STATE OF NORTH CAROLINA
DEPARTMENT OF TRANSPORTATION

Addendum No. 1

RE: Contract ID: C201709
WBS# 12CR.10551.4, 12CR.20551.5
Lincoln County
2 Sections of NC-27 and
11 Sections Of Secondary Roads.

January 16, 2007 Letting

## SUMMARY OF QUANTITIES

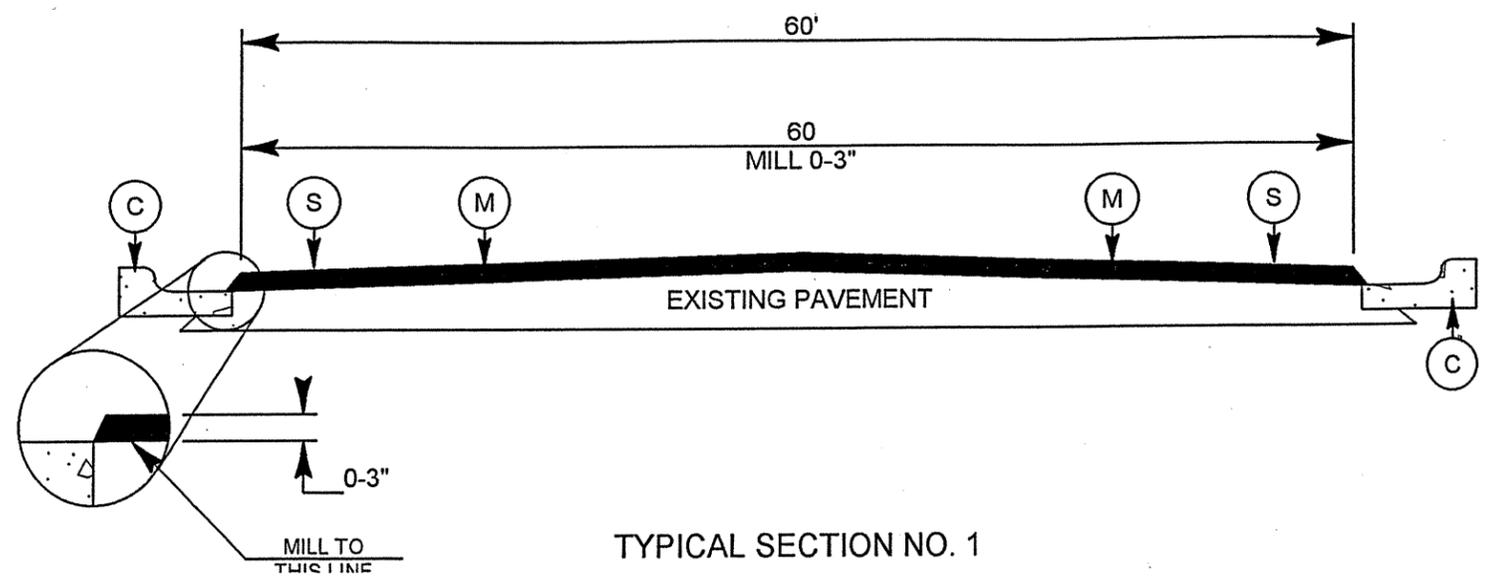
On Sheet No. 1, the typical numbers were revised in the column labeled "Typ. No." Please void Sheet No. 1 in your sketch maps and staple the revised Sheet No. 1 thereto.
